This consult is in reference to Setback Variance VA-23-00008 *Hendrix*.

TO: All Staff
FROM: Public Works Plan Review Team
DATE: October 11th, 2023
SUBJECT: Public Works Comments: VA-23-00008 Hendrix

**SITE PLAN**  
**LOT 1, BLOCK E, PINE LOCH SUN I**  
**A PORTION OF THE SW 1/4 OF THE NE 1/4 OF SECTION 2,**  
**TOWNSHIP 20 NORTH, RANGE 14 EAST, W.M.,**  
**KITTITAS COUNTY, WASHINGTON**

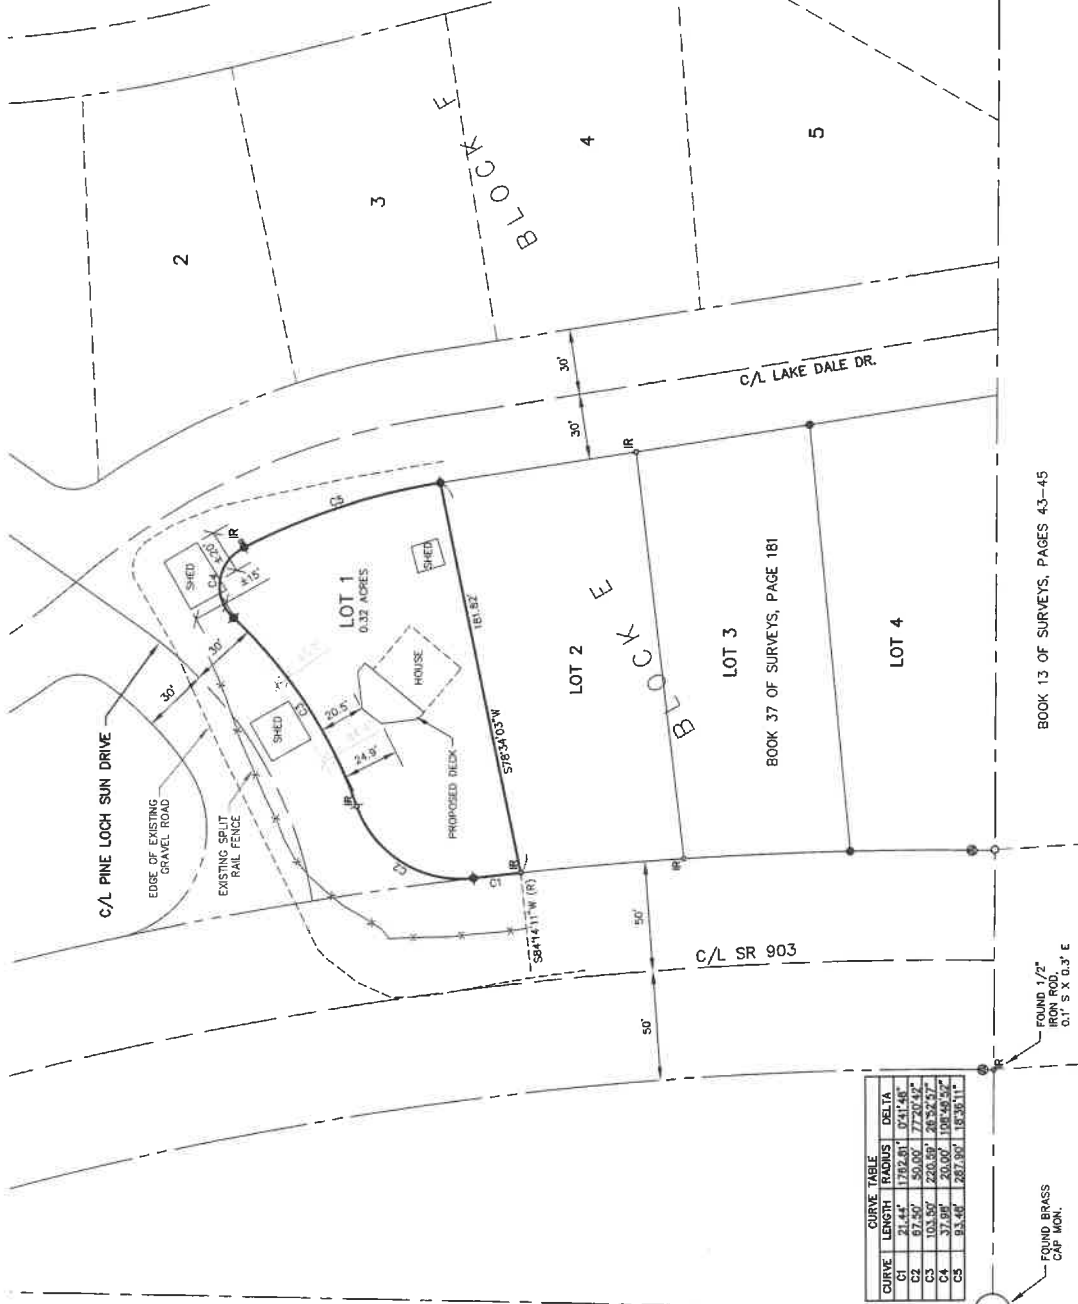
SURVEY	<ol style="list-style-type: none"> 1. Given the tight tolerances, it is highly recommended that the garage be staked out by a land surveyor licensed in the State of Washington. 2. Given the tight tolerances, no portion of swinging doors, eaves, or building footings should extend into the remaining 7.5' setback.
TRANSPORTATION CONCURRENCY	<p>No transportation concurrency application will be required for this project. (KAH)</p>
FLOOD & WATER MITIGATION/ METERING	<p>No comments. (SC)</p>
